**Consultation Response from Ryan Kinder KC,  
Highways Development Management**

**2023/91405 Part of former St Luke's Hospital site, Blackmoorfoot Road, Crosland Moor,  
Huddersfield, HD4 5RA**

**Erection of foodstore (class E) with associated access, parking, servicing area and  
landscaping**

date August 2023  
status Planning  
scale 1:500 @ A3  
drawn KA checked BM  
job no. 2783 dwg no. P413 rev. D

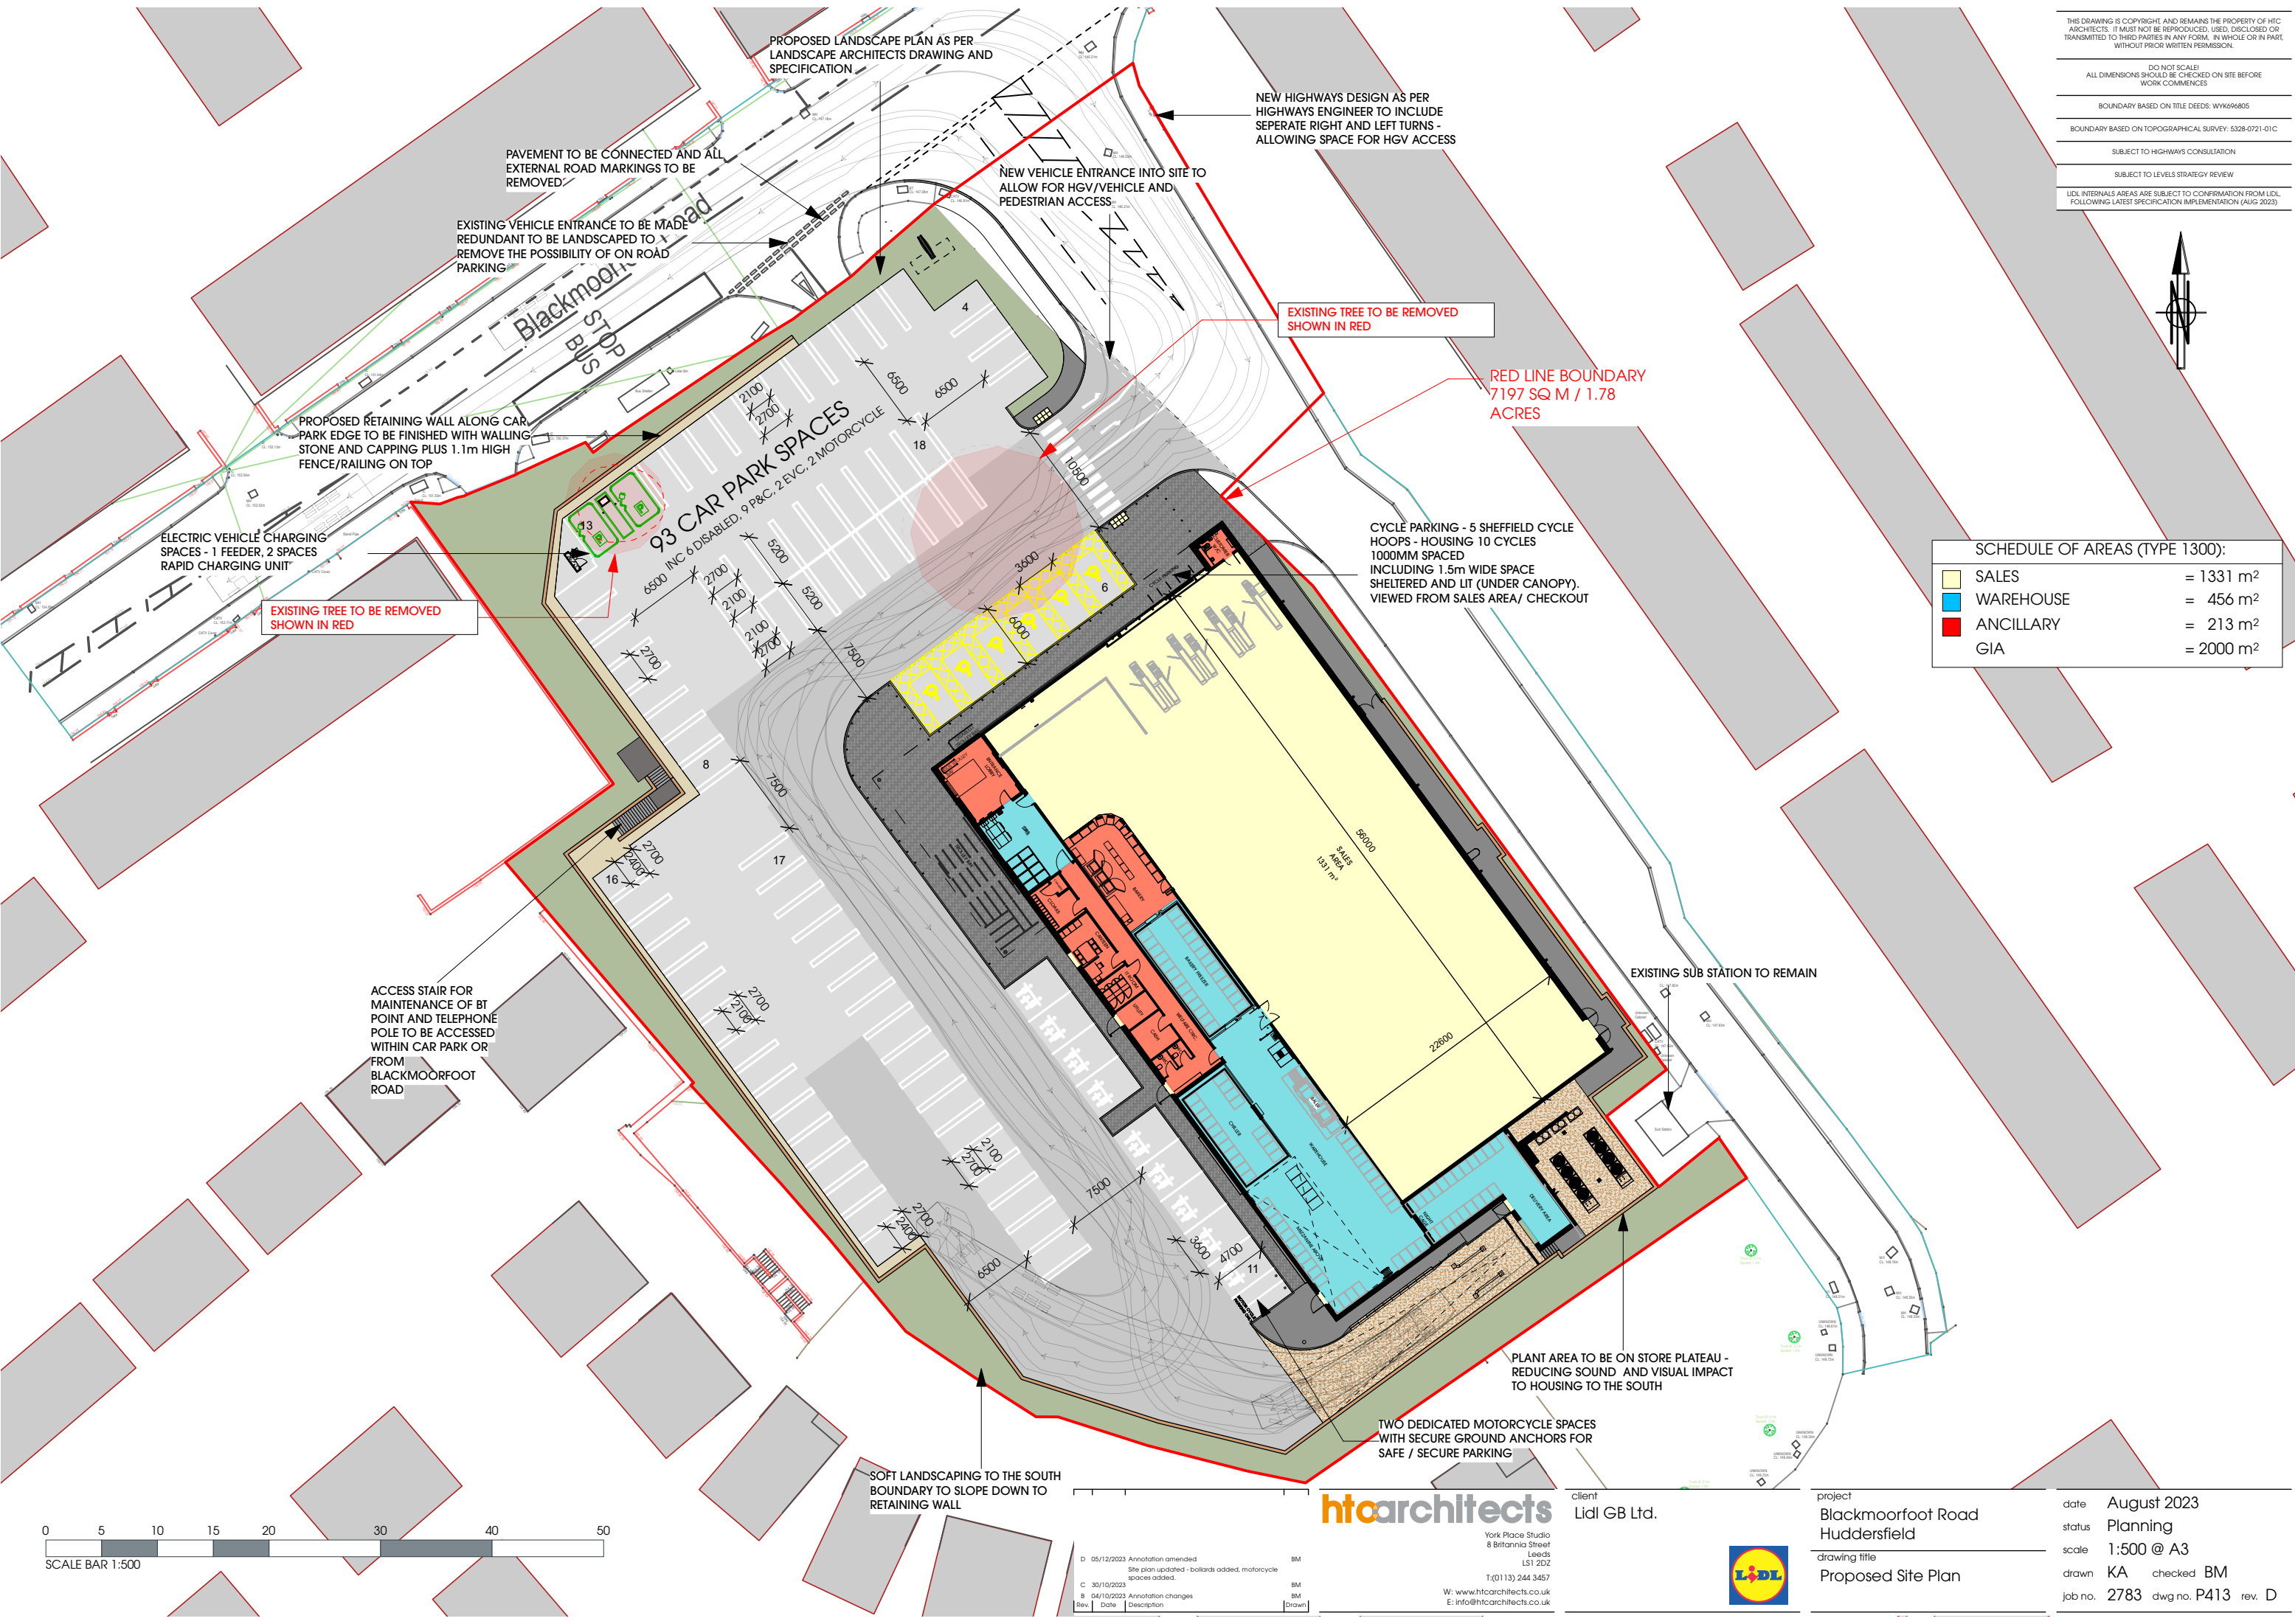
Amendments to internal site layout to accommodate a suitable level of parking.

Reconfiguration of internal layout to ensure minimal conflict with deliveries and customer parking, original position of food store preferred option (plan ref R/2682/1A) dated Mar 23..

A priority giveway arrangement is proposed from the car park onto Turnstone way, the point of access is subject to review, it is suggested that the submitted indicative plan (ref R/2682/1A), where the site access is further away from the junction with Blackmoorfoot Road is the preferred option from a highway perspective to negate conflict with vehicle movements to and from the site and deliveries etc.

It is suggested that the internal layout be reverted back to the previous arrangement (ref R/2682/1A), this is preferred given the detail of the internal tracking of delivery vehicles. It is considered that there is less conflict with customer parking and ease of access to the loading bay. In addition the site access onto Turnstone Way is further away from the junction of Blackmoorfoot Road and will minimise conflict in this respect.

Regarding waste collections this site will be serviced with the same arrangements as deliveries, the comments above regarding the layout are the same on this matter.
